**BUILDING CODE OF AUSTRALIA
REPORT**

**Australia Habitat and Taronga Wildlife
Retreat
Bradleys Head Road, Mosman, NSW,
Australia**

Date	Revision Number	No. of pages	Issue or Description of Amendment	Checked By	Approved By	Date Approved
6.10.2016	H	20	BCA Report for DA Submission	Andrew Brohier	Geoffrey Pearce	6.10.2016

Figure 3-9: Level 1 – Restaurant

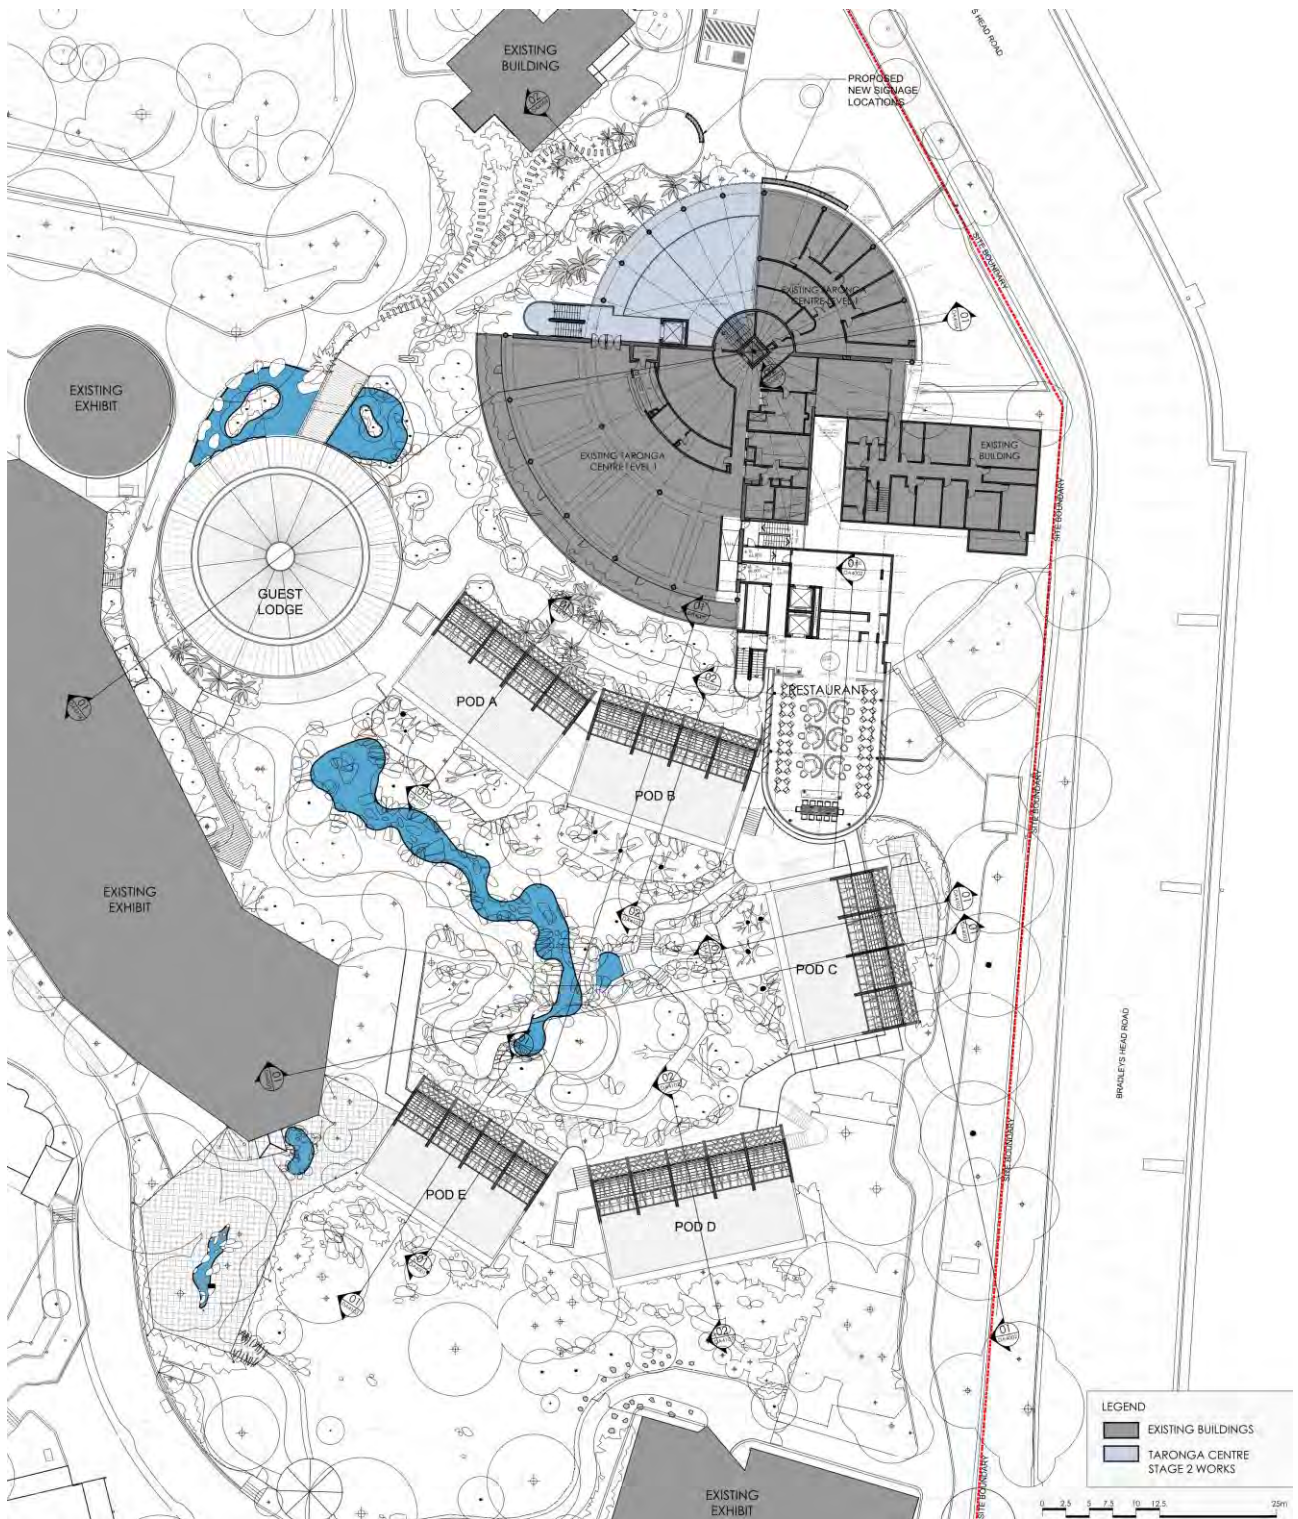
Level 1

- Travel distance is 23m in lieu of 20m to a single exit.

Figure 3-10: Level 2 – Terrace

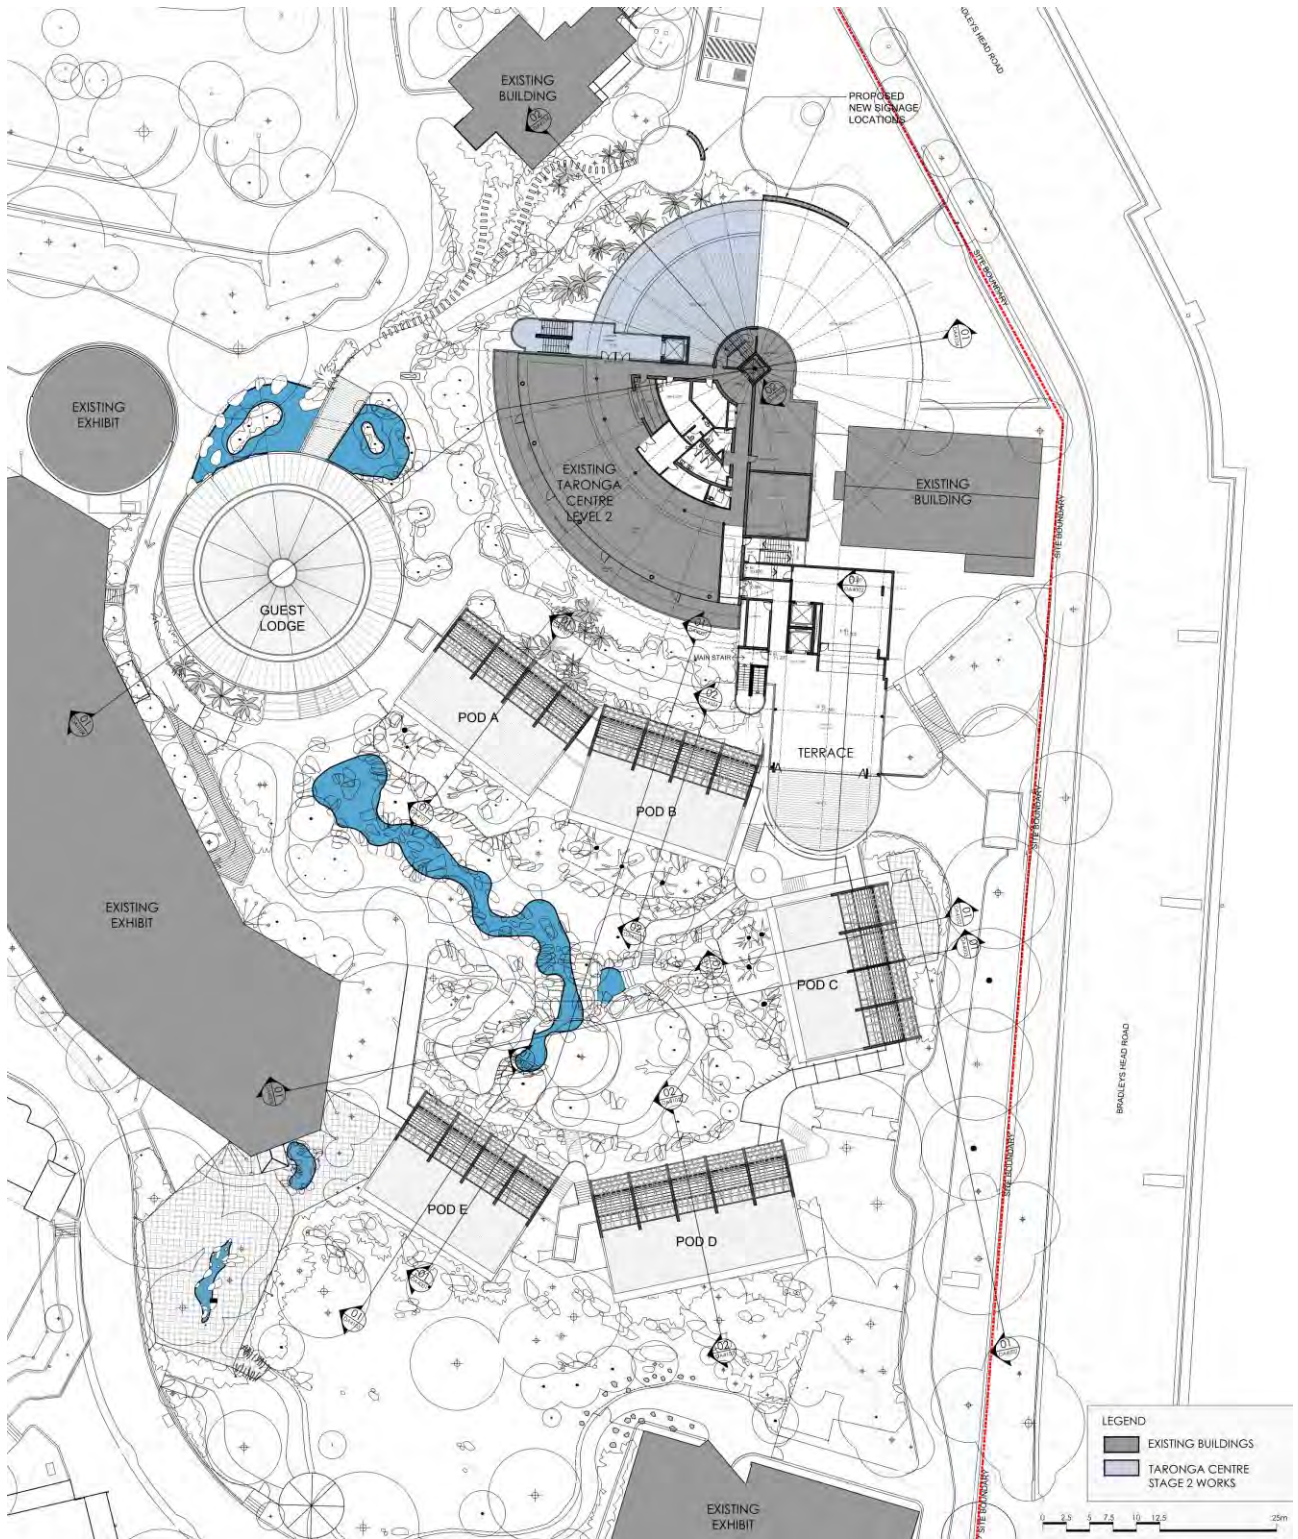
Level 2

- Travel distance is 22m in lieu of 20m to a single exit.

Figure 7-1: Extended distance of travel on Level A

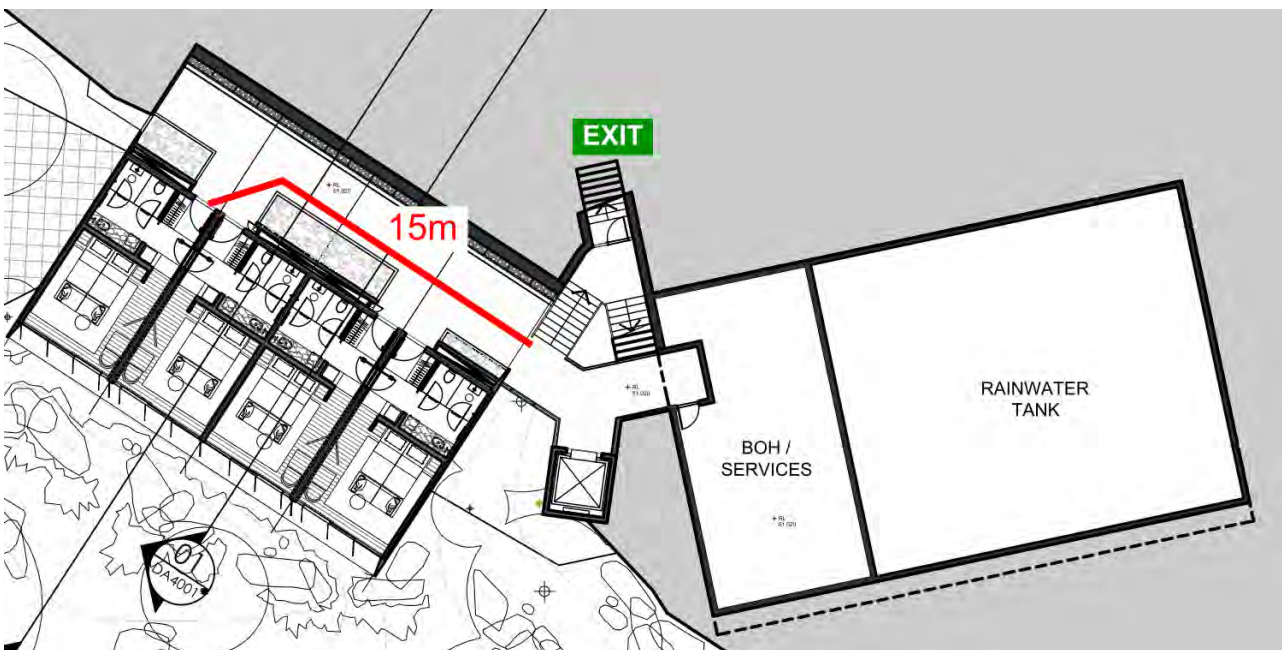
Level A,B

- Travel distance from entrance doorway of a sole occupancy unit is up to 15m in lieu of 6m

Figure 7-3: Extended distances of travel on Level C

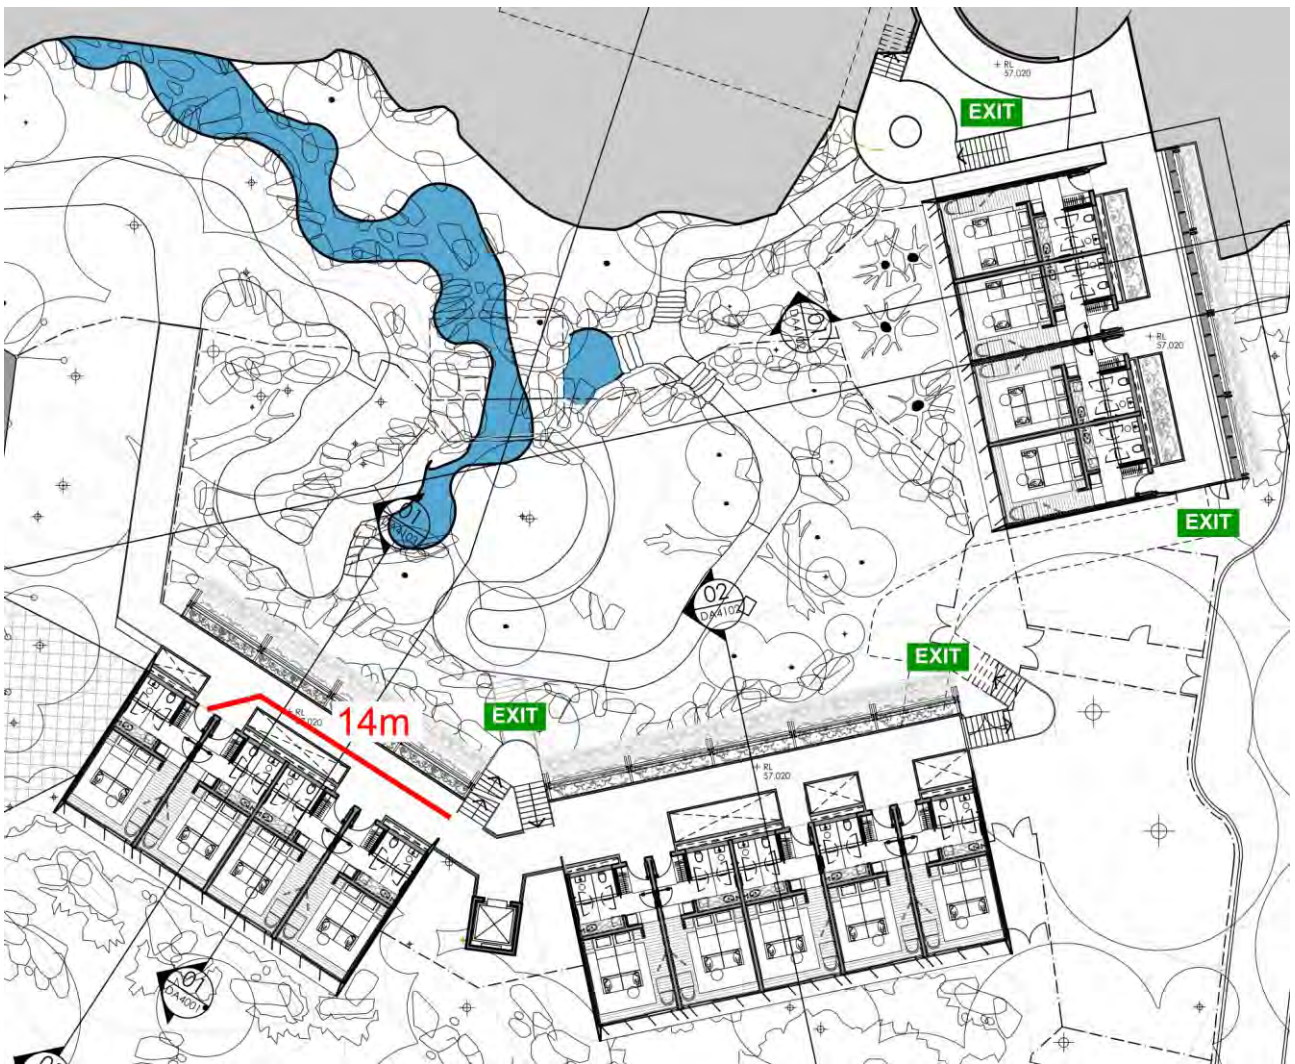
Level C

- Travel distance is up to 36m in lieu of 20m from in front of the lift

Figure 7-4: Extended distances of travel to an exit and between exits on Level D

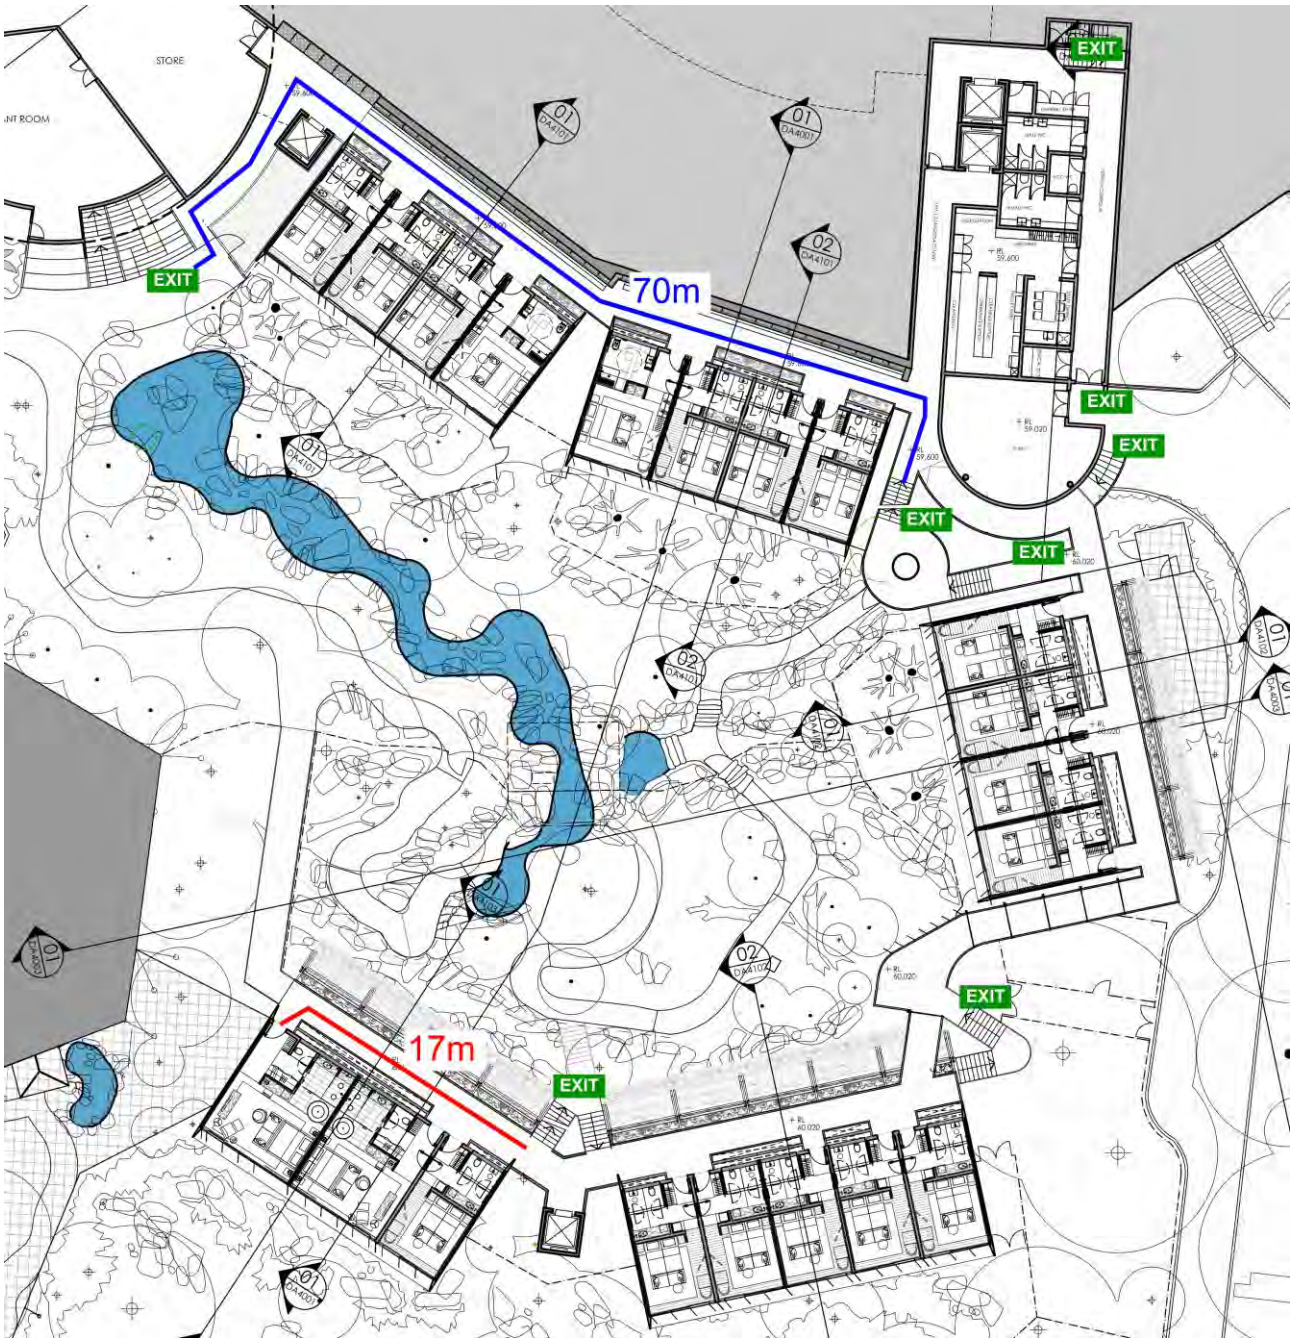
Level D

- Travel distance is up to 30m where 2 exits are available

Level D

- Travel distance is up to 28m in lieu of 20m from within Platypus Keeper back of house area

Level D

- Distance between alternative is up to 68m in lieu of 45m

Figure 7-5: Extended distances of travel between exits on Level E

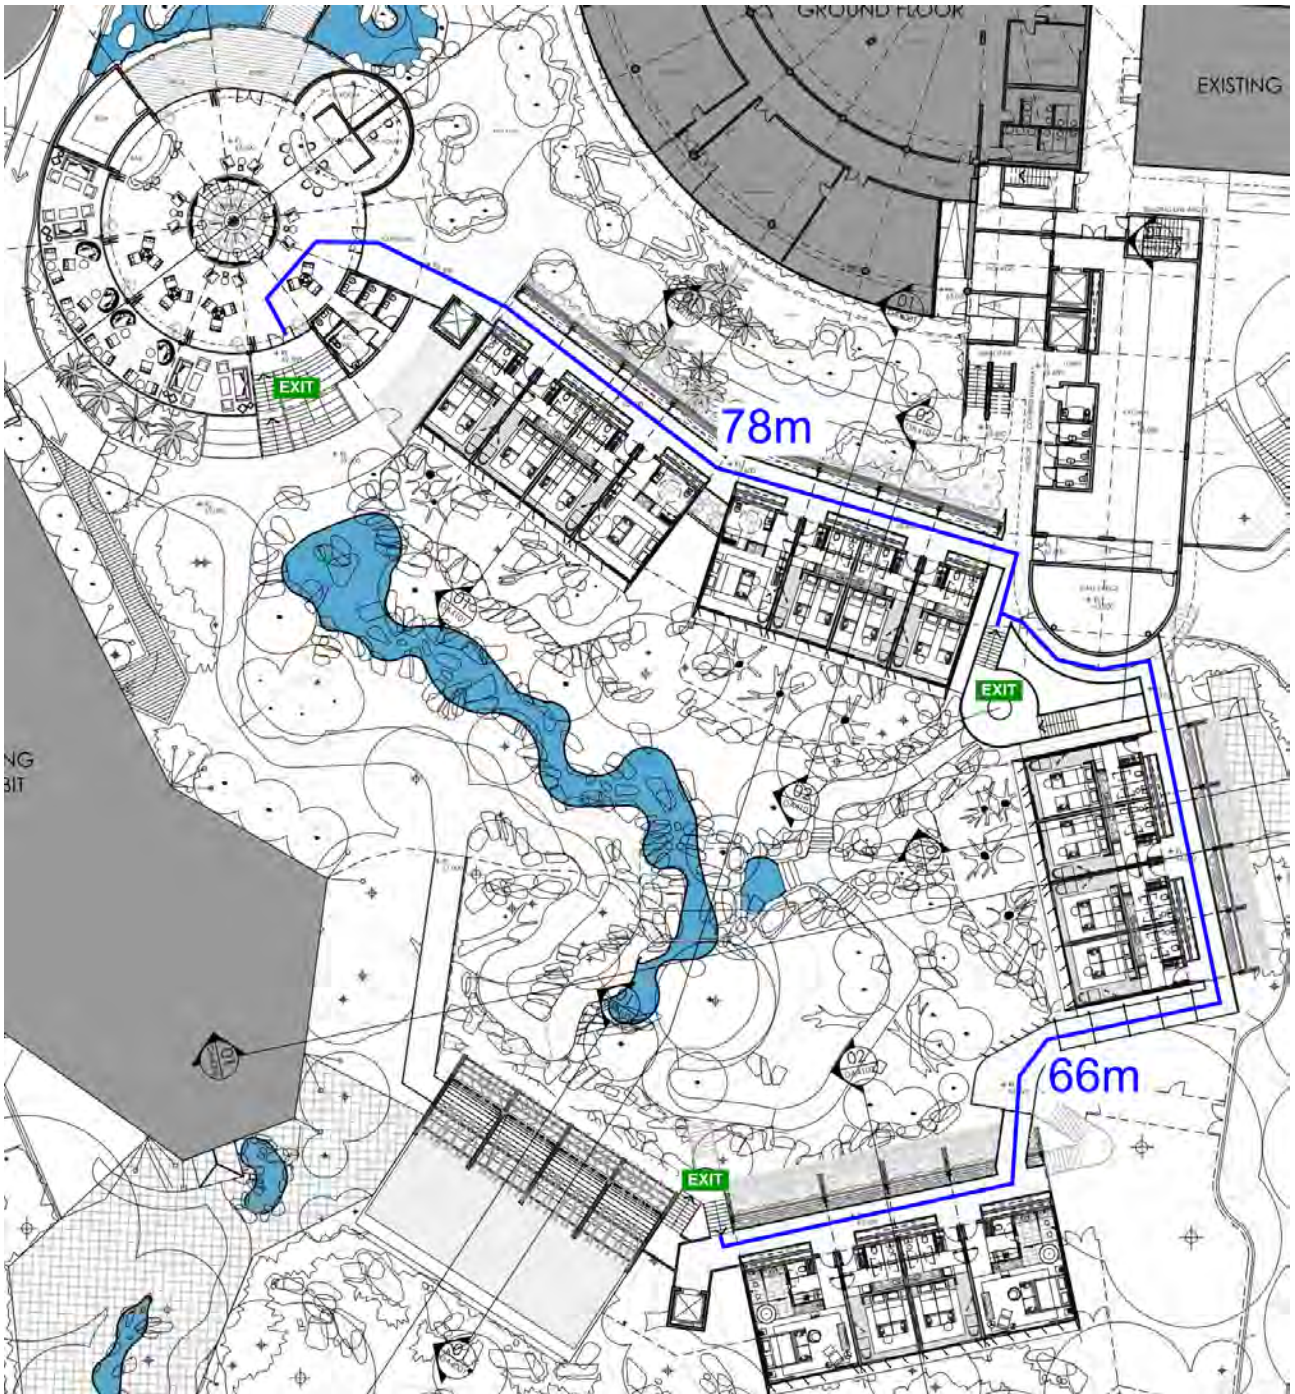
Level E

- Travel distance is up to 29m where 2 exits are available

Level E

- Distance between alternative is up to 73m in lieu of 45m
